January 11, 2023

RE: Letter of Intent for Board of Adjustment Variance Request for Setbacks at 13830 Overlook Place

SITE PLAN

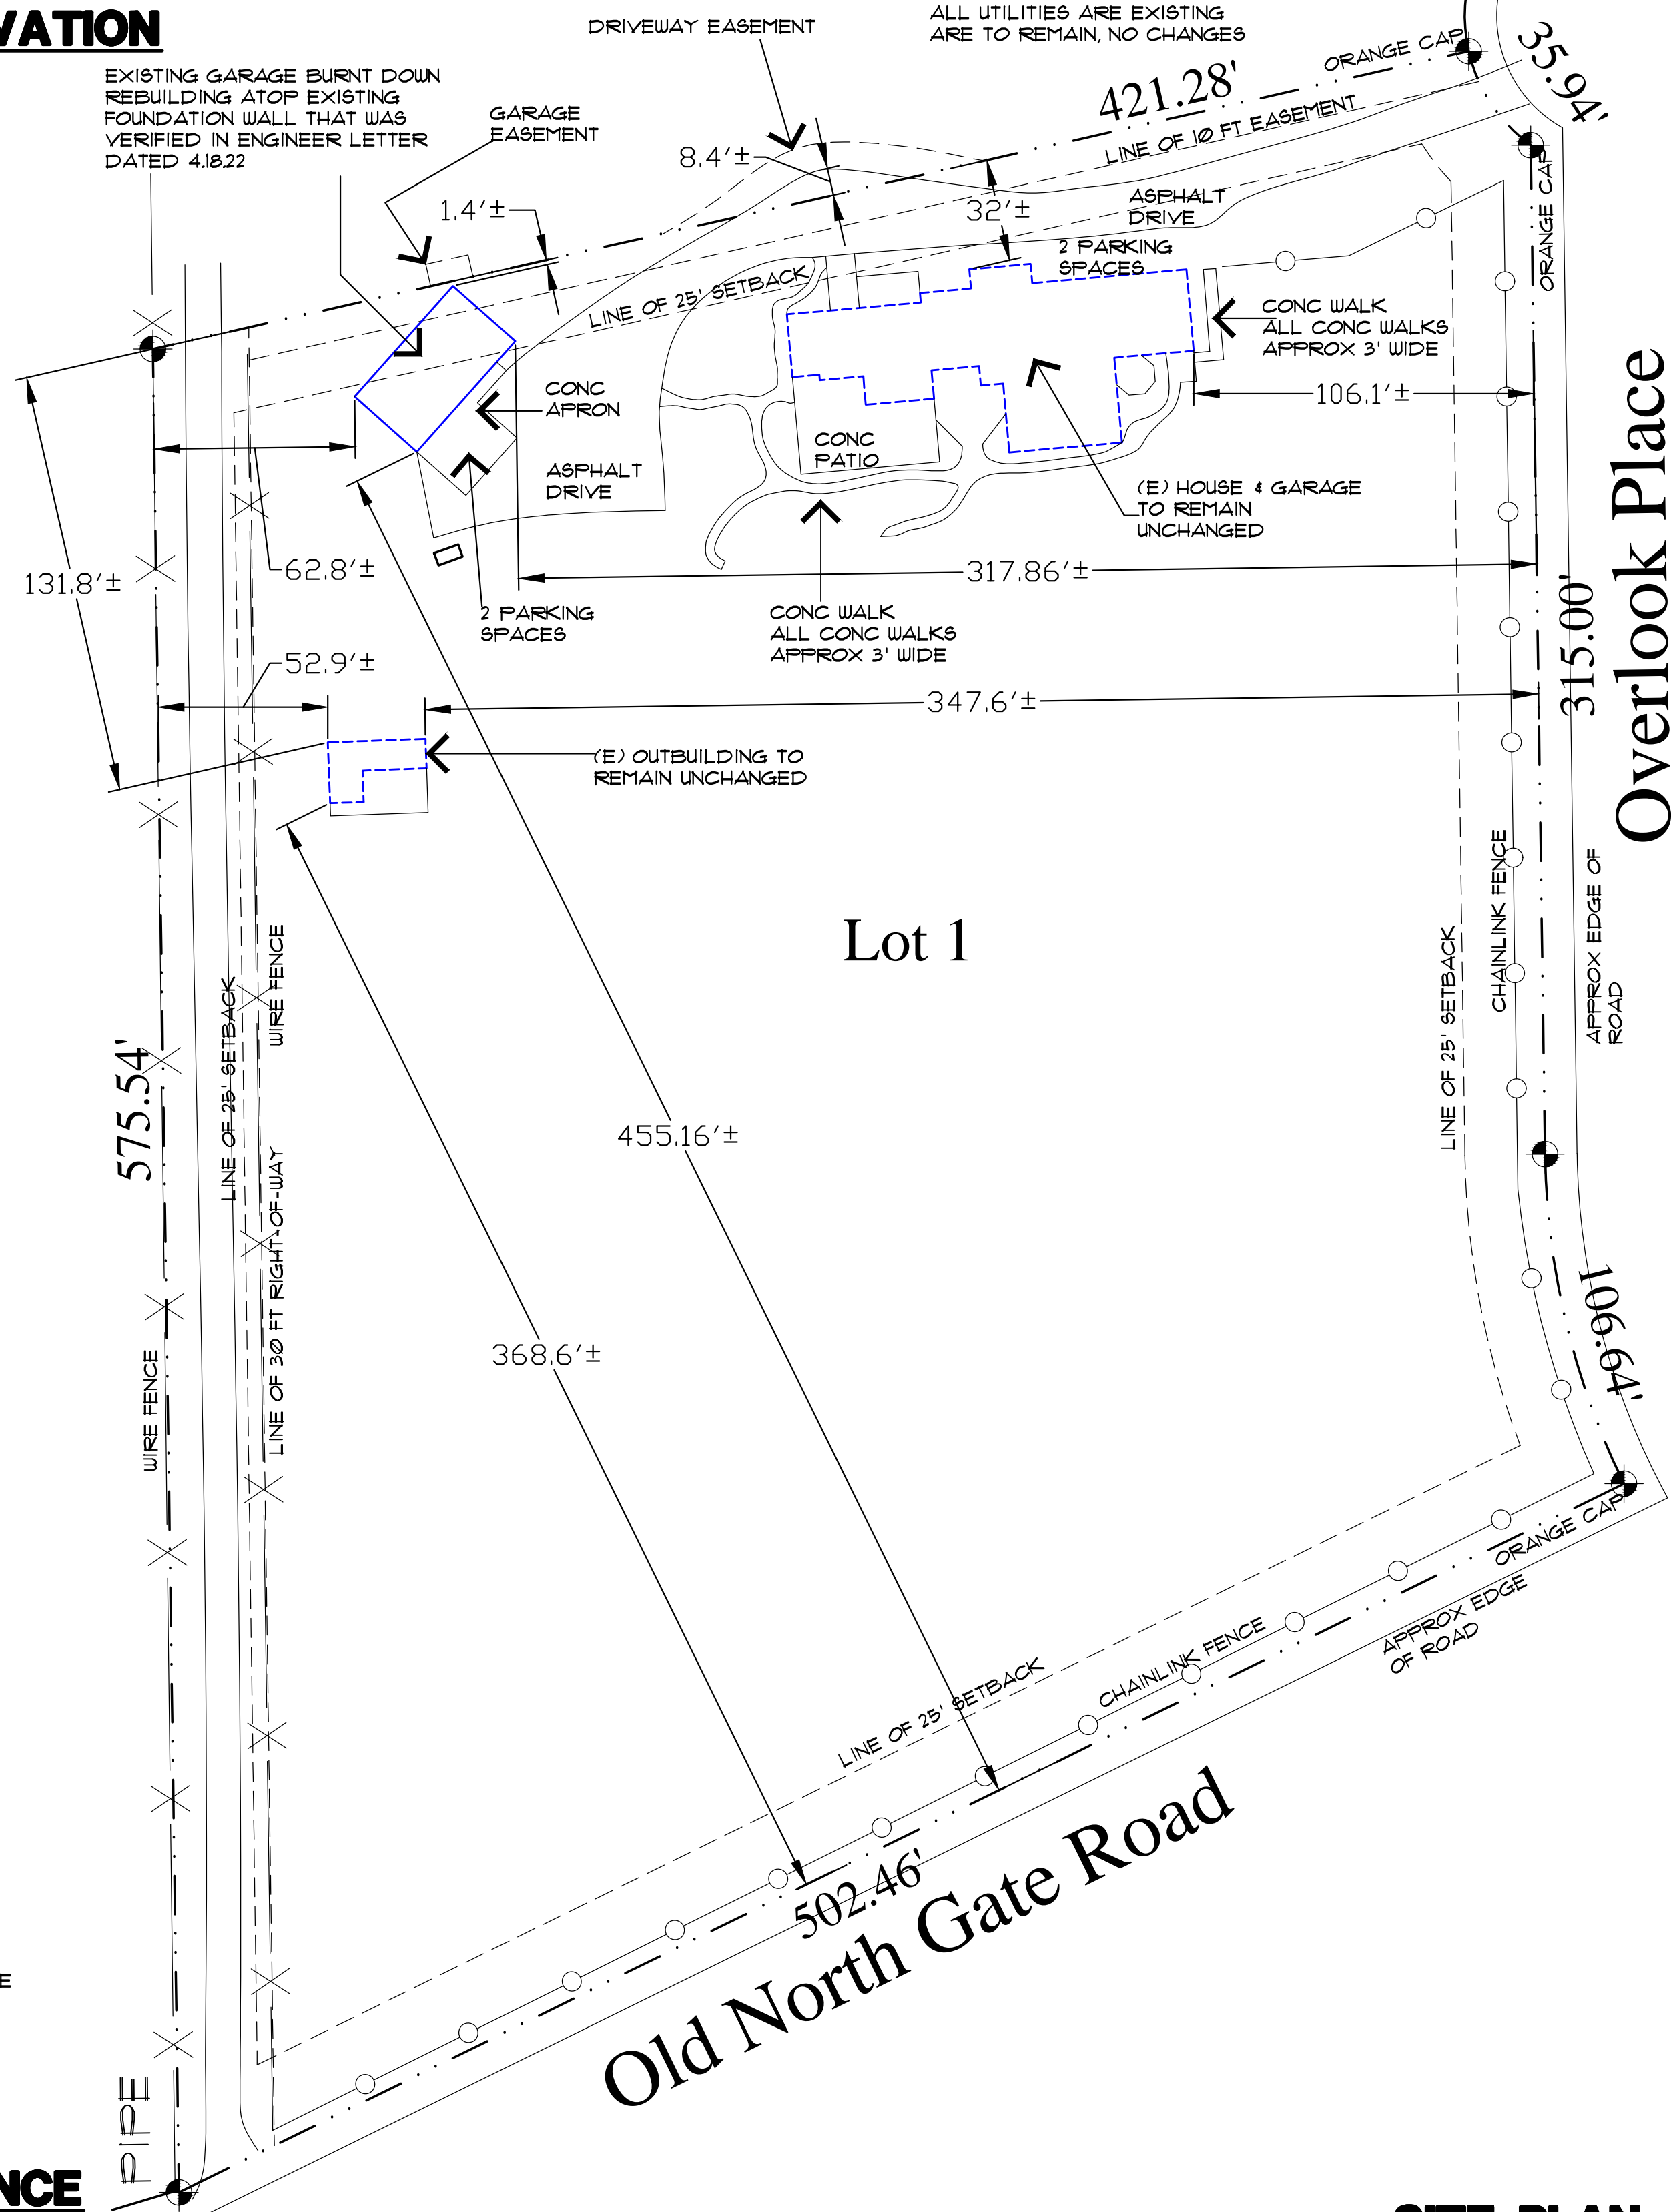
State the proposed garage's square footage and total land disturbance. Discuss if there will be additional grading around the garage's foundation. Additionally, provide a statement confirming the proposed structure will not adversely impact existing drainage patterns.
